**Planning Department
Transportation Development Services**

**Re: Lincoln Complex Building M Renovations
915 Locust St.
Traffic Circulation Layout
Engineer's/Architect's Stamp dated 7-31-15 (K15-D047)**

Based upon the information provided in your submittal received 8-3-15, the above referenced plan cannot be approved for Building Permit until the following comments are addressed:

C-104A

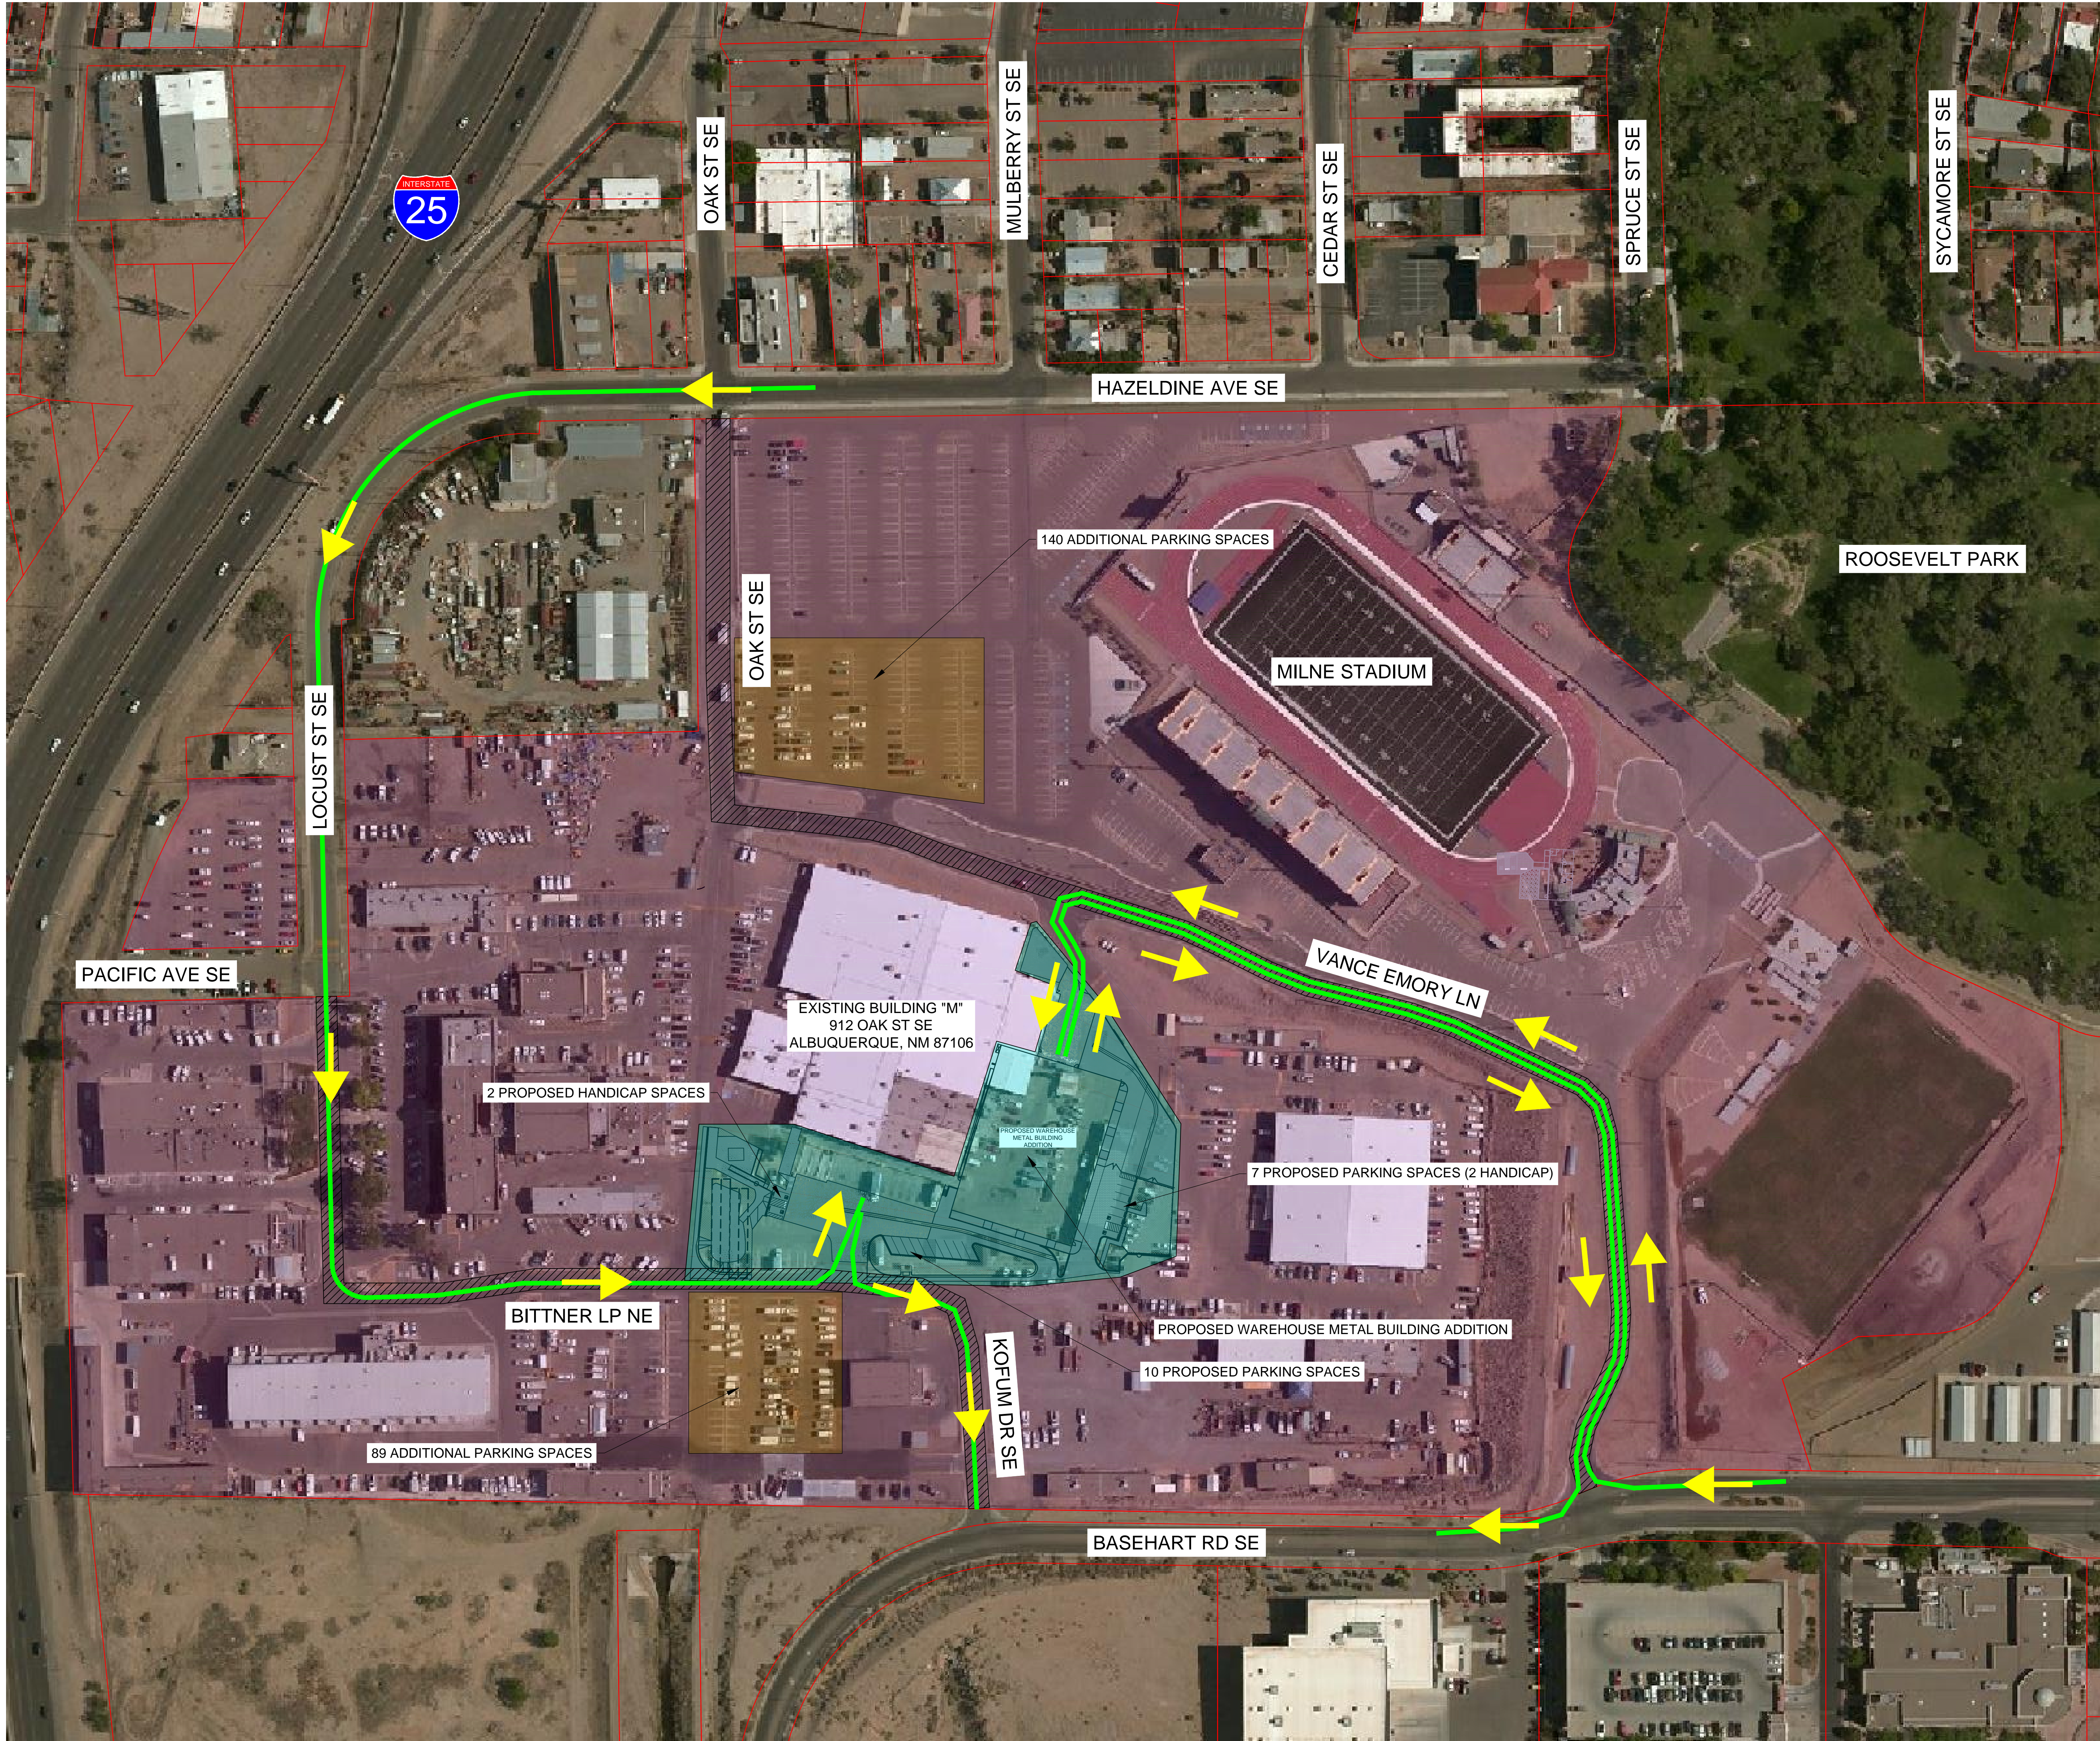
1. Please show a vicinity map showing the location of the development in relation to streets and well known landmarks. Please clarify the site address of Building "M" and the proposed development.

2. List the number of parking spaces required by the zoning code as well as the proposed number of parking spaces.
3. Clarify the extents of the current phase. Please detail existing and proposed buildings, parking spaces and public or private road ways.

14. Design delivery vehicle route needs to be shown.
15. Service vehicle and/or refuse vehicle maneuvering must be contained on-site; provide a copy of refuse approval.
